DISTRICT COUNCIL
NORTH OXFORDSHIRE

Our Ref: 13/00321/OUT

Application under the Town and Country Planning Act 1990 for the following: OUTLINE - 1000 dwellings together with a local centre including retail (A1), financial services (A2), restaurants (A3-A5), up to a combined total floorspace of 1000m², employment space (B1) up to a total floorspace of 5000m² with the B1(a) office component limited to a maximum of 2,500m², associated car parking, a community primary school (including space for community uses (D1) and assembly and leisure uses (D2)), green infrastructure including formal and informal open space, amenity space, retained hedgerows, structural landscaping, supporting infrastructure (including gas, electricity, sewerage, water, telecommunications), sustainable urban drainage systems, new connection to the A361 Bloxham Road, pedestrian and cycling connections to the surrounding footpath and cycle network and any necessary demolition and ground remodelling

REQUIREMENTS UNDER REGULATION 22 (1) OF THE TOWN AND COUNTRY PLANNING (ENVIRONMENTAL IMPACT ASSESSMENT) REGULATIONS 2011 TO PROVIDE FURTHER INFORMATION IN RESPECT OF THE ENVIRONMENTAL STATEMENT

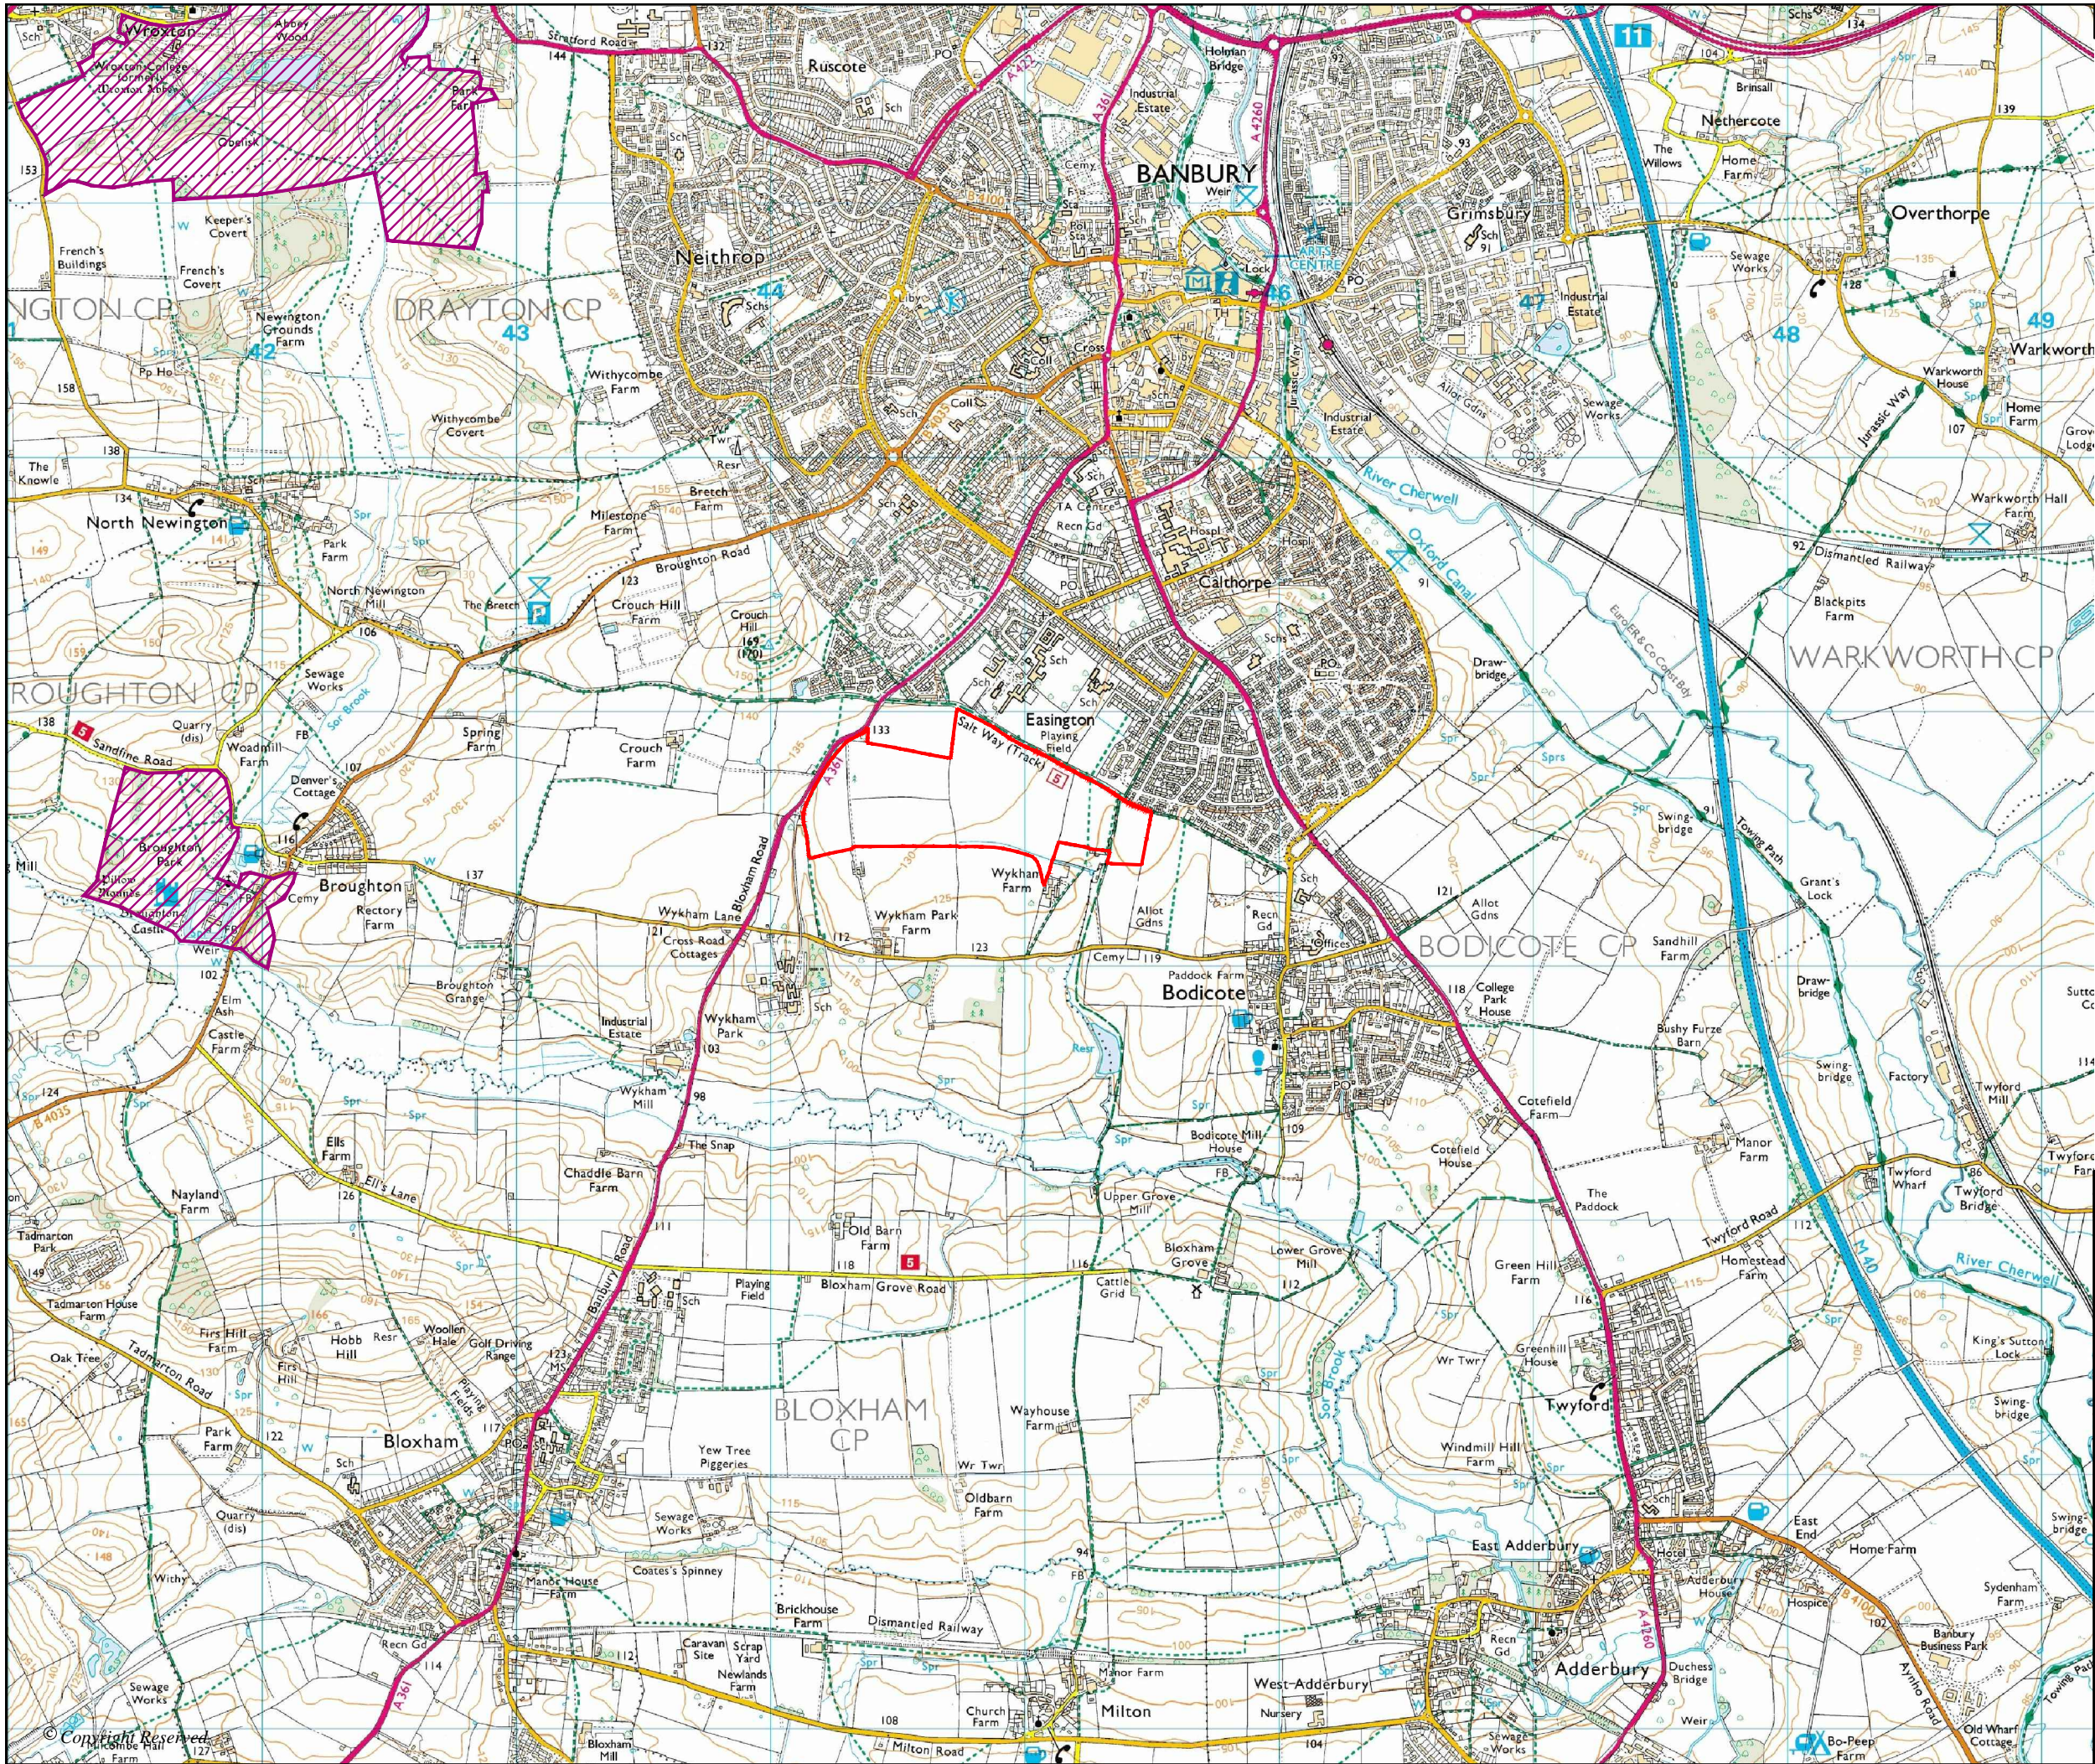
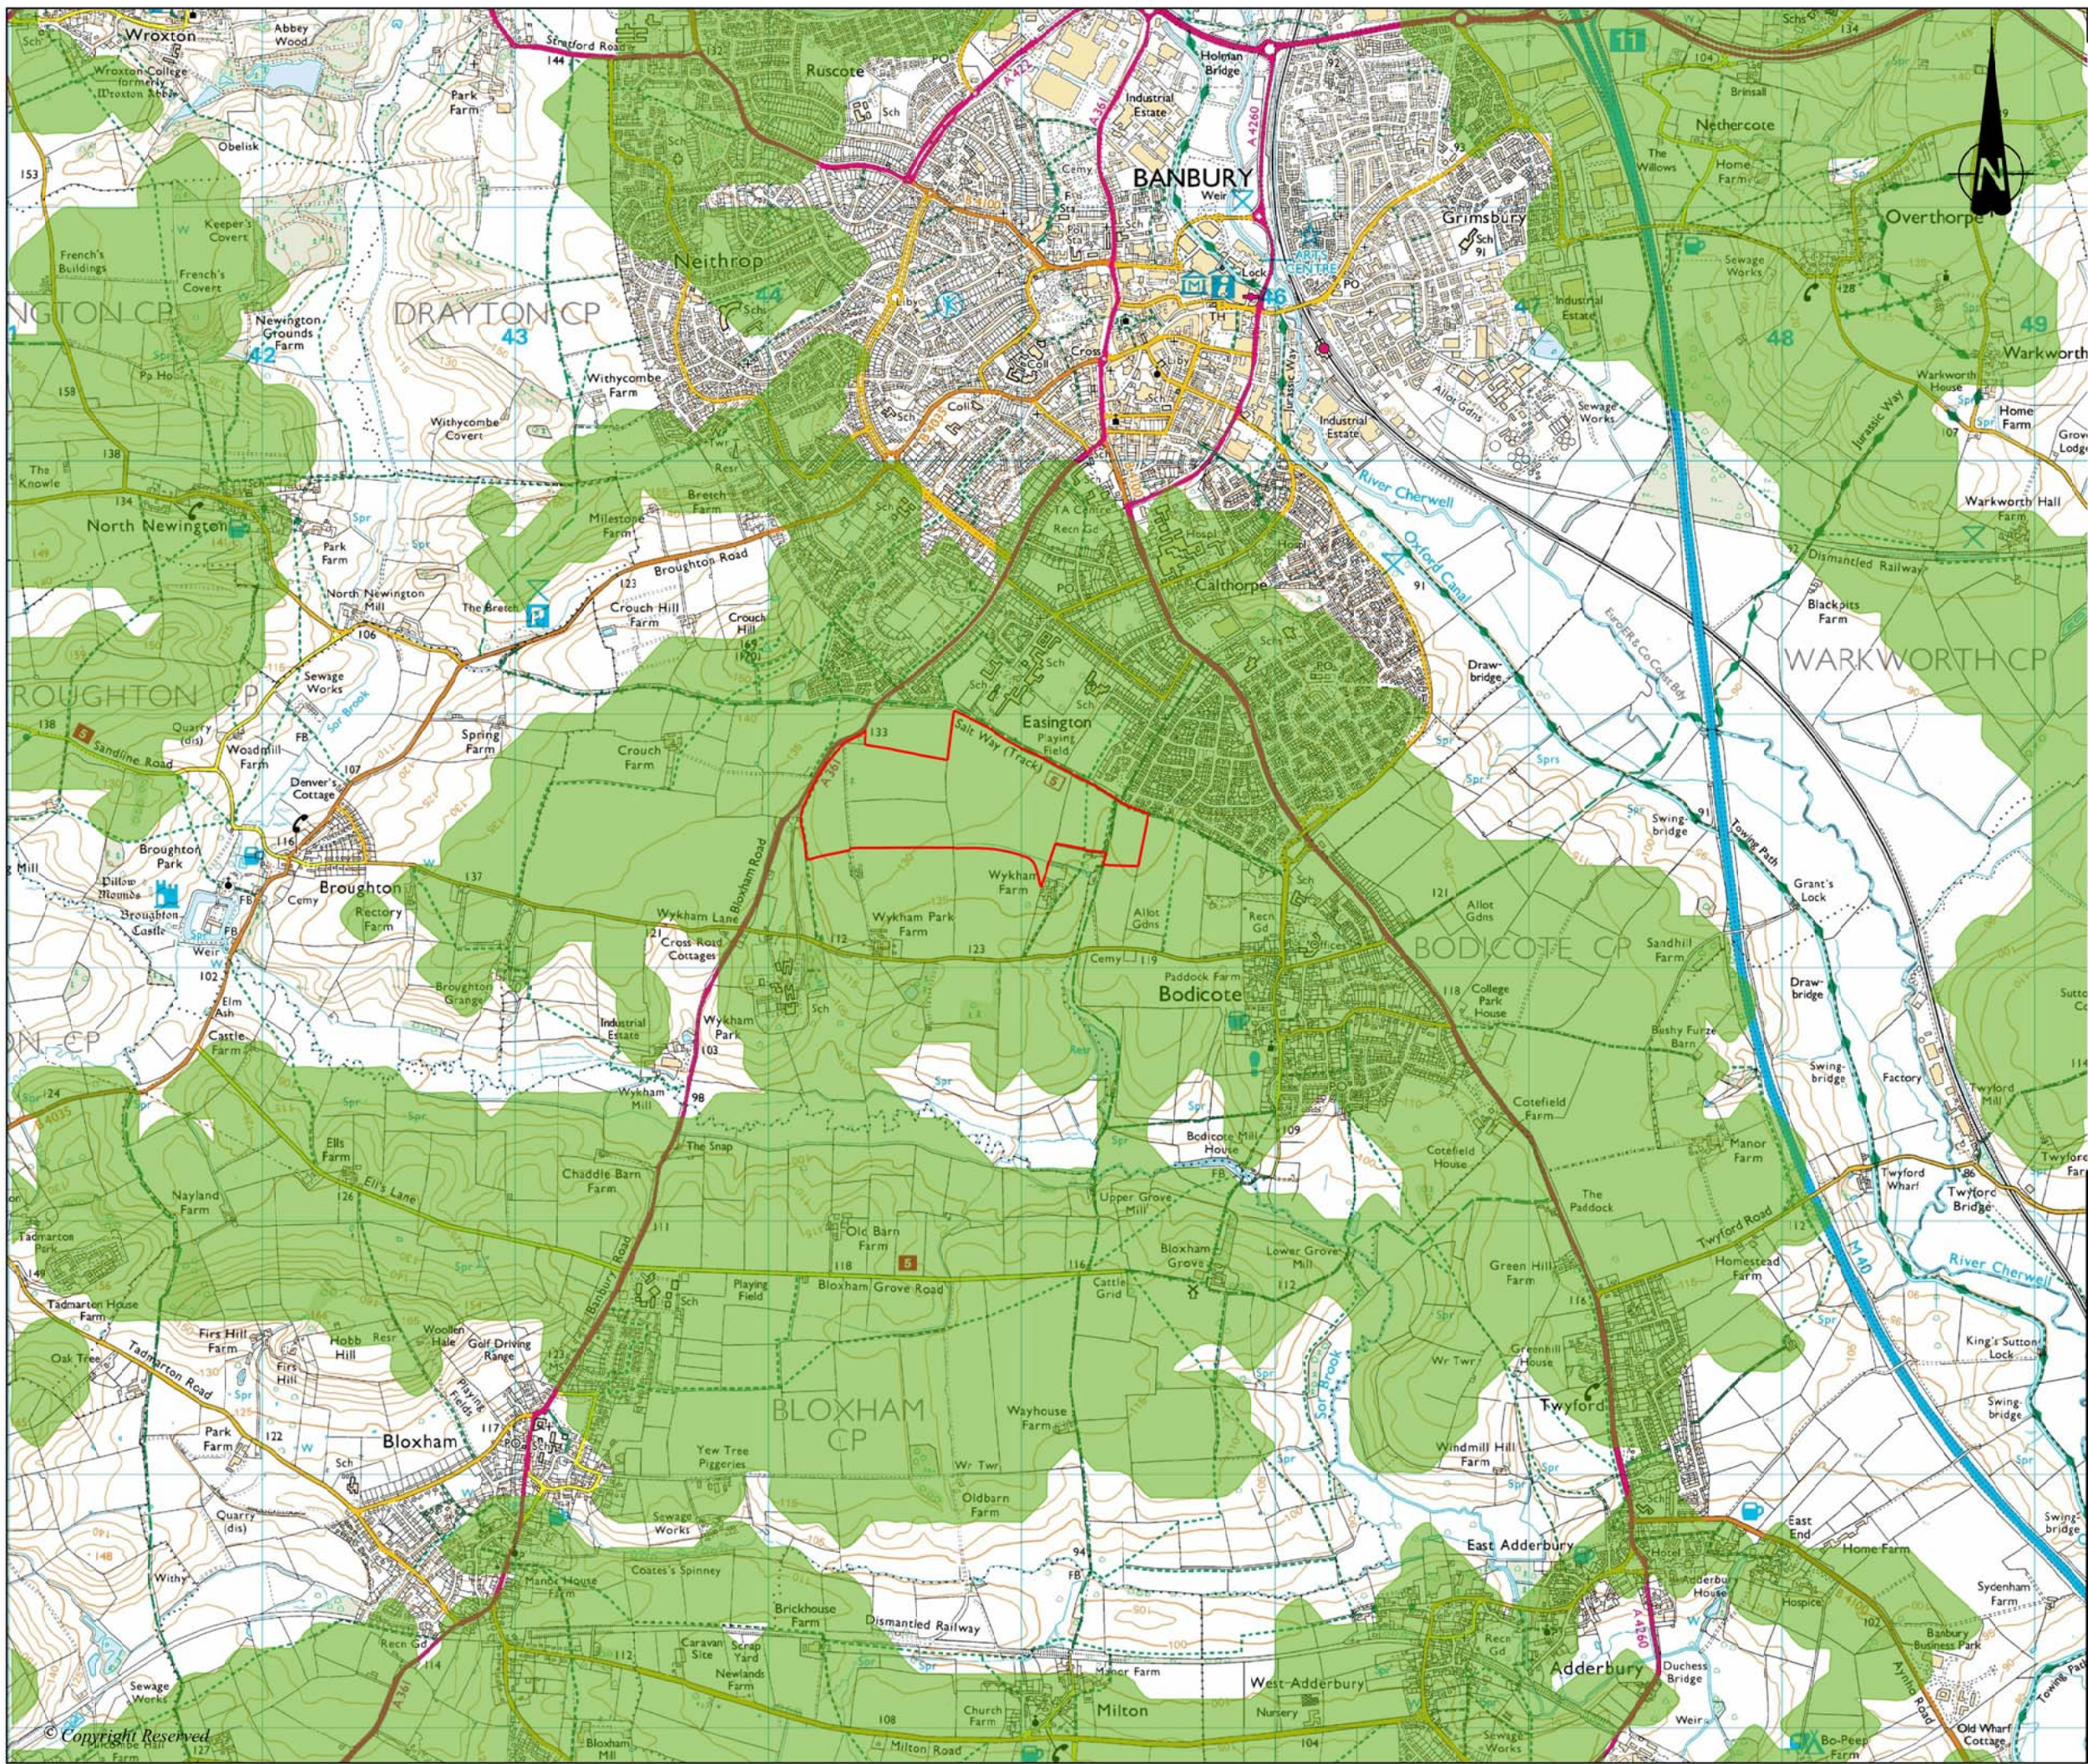
- 9.1.5. The Zone of Theoretical Visibility (ZTV) of the development has not been identified. The Council wishes to see this illustrated on a plan of a suitable scale. The ZTV should include a methodology and details of datasets used to create the ZTV.
